Inspector's Report ABP321043-24

Whether the alterations of column at front/side windows side windows to concrete blockwork on four holiday pods is or is not development and or is or is not exempted development.

Shanks Mare, Collegelands and Arodstown, Summerhill, County Meath.

SOUTH-EAST (FRONT) ELEVATION  
Scale 1:100

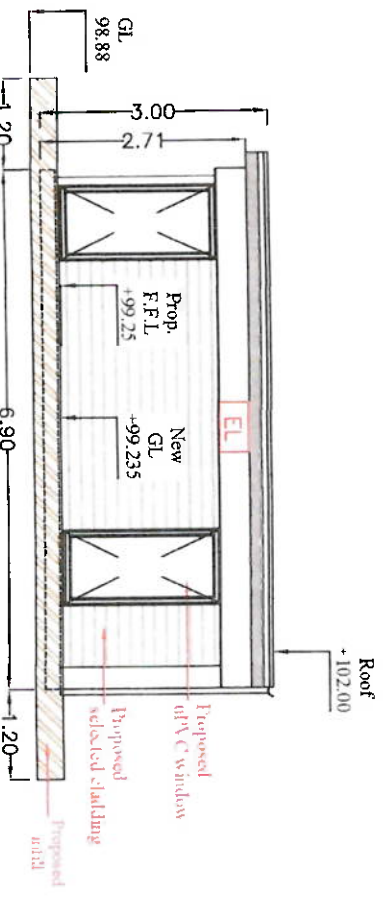
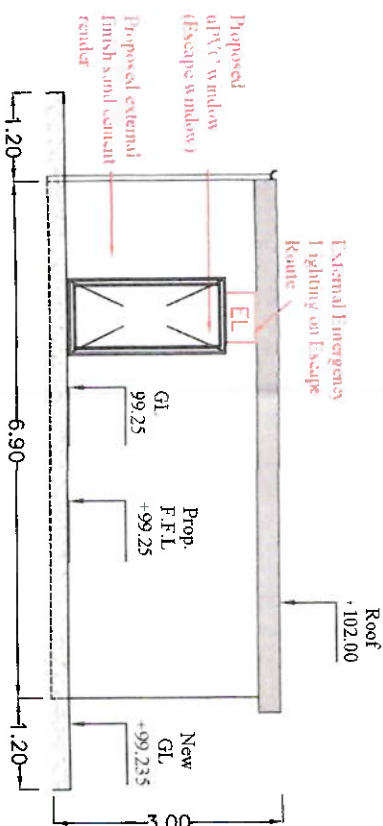
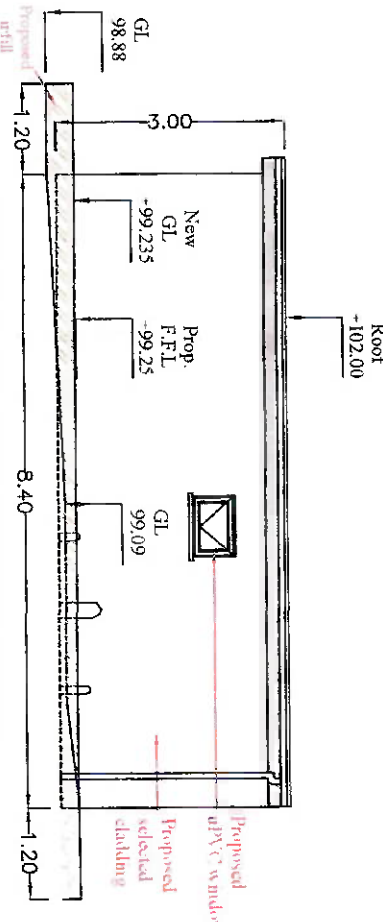
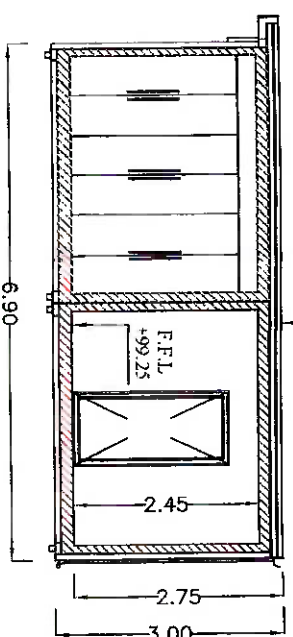
- 8.2.5. The information as submitted by the owner/occupier to Meath County Council in the request for a declaration includes the planning drawing and also a further set of drawings of the pods as constructed with detail in relation to the finishes etc. which would appear to have prepared for fire certificate compliance.

- 8.2.10. There is no reference in the planning to a requirement for steel columns or specific requirements in relation to external finishes.
- 8.2.11. Addressing the question raised and submitted to the Board based on the definition of works, the alterations of column at front/side windows side windows from steel to concrete blockwork on four holiday pods involves the carrying out of 'works' through an act of construction or alteration and therefore I considered solely and strictly within this definition would constitute development. Accordingly, having established that the works in question constitute development within the strict definition and meaning of the Act it would be necessary to ascertain whether or not they can be considered to be exempted development.

- 8.3.8. I am satisfied that given the nature and limited scale of the alteration in terms of the material used, this alteration is of minor significance and in the context of the overall development as approved under PA Ref. No. 22629 is not a material alteration and that the alteration is not inconsistent with the character of the structure and that it would not be inconsistent with the character of neighbouring structures.

- 8.3.12. I therefore consider, the alterations of column at front/side windows side windows to concrete blockwork if it were it is deemed as development complies with the exempted development provisions of Section 4(1)(h) and therefore would be exempted development being works which do not materially affect the external appearance of the structure so as to render the appearance inconsistent with the character of the structure or of neighbouring structures as the works are internal and do not materially affect the external appearance of the structure.

Drawing Title			
PROPOSED GUEST "PODS" PLANS SECTION & ELEVATIONS			
Drawn By	Date	Scale	
REGINA MCLOUGHLIN	APRIL 2022	1:100 @A3	
Revision	Drawn Status	Drawn No.	
	PLANNING ONLY	19-131-104PD

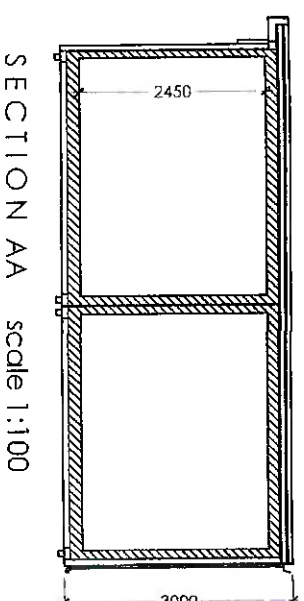
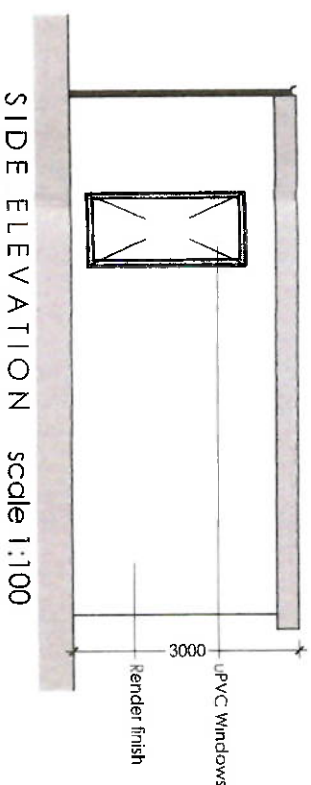
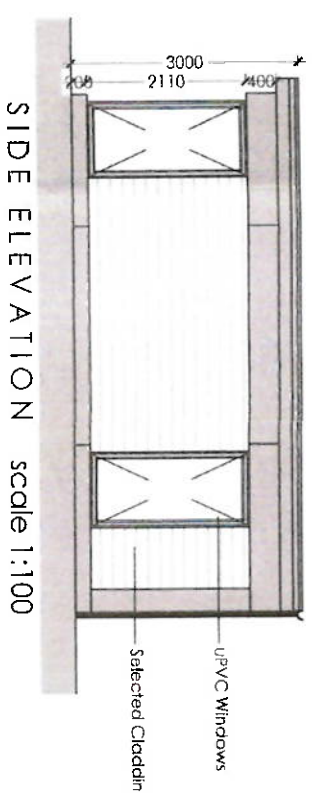
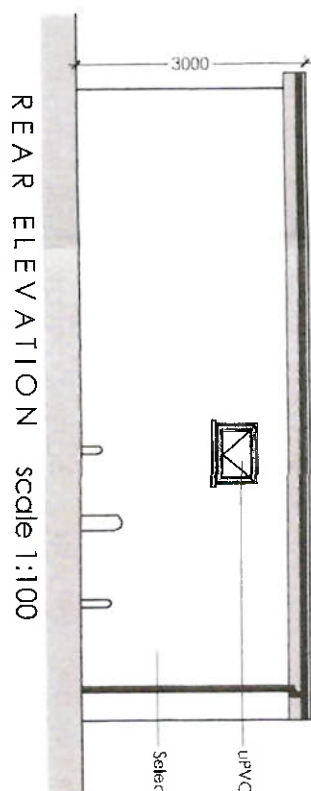
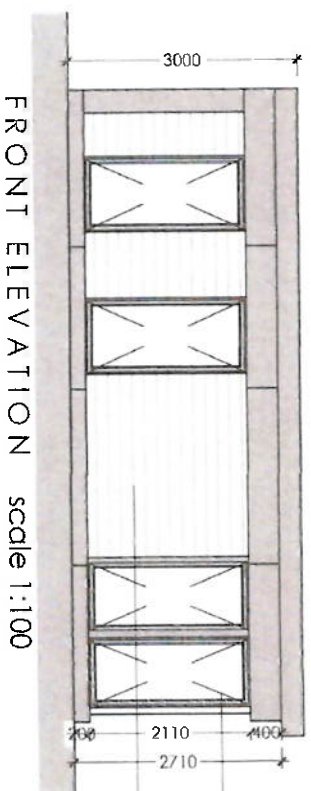
- 8.2.4. Documentation submitted with the application indicated a plan, elevation and sections of the proposed pods. Information in relation to external finishes on the drawings referred to selected cladding, render finish and UPVC windows. No specific details are indicated in relation to the use of steel and concrete columns on the external elevations.

- 8.2.6. Based on the planning drawings and the conditions which were included in the grant of permission under P.A Ref. No. 22629 there is nothing to indicate specific requirements in relation to the use of steel or concrete columns.

- 8.2.7. There is nothing to suggest that permission was granted for using or not using either steel or concrete columns in the elevations.
- 8.2.8. Condition No. 1 of the grant of permission states *“the development shall be retained, constructed and completed in accordance with the plans and particulars lodged with the Planning Authority on the 16/05/11 and further information received on the 05/09/2 and 12/09/22 except where conditions specify otherwise. Where such conditions require details to be agreed with the planning authority, the developer shall agree such details in writing with the planning authority prior to the commencement of development and the development shall be carried out and completed in accordance with the agreed particulars”*.
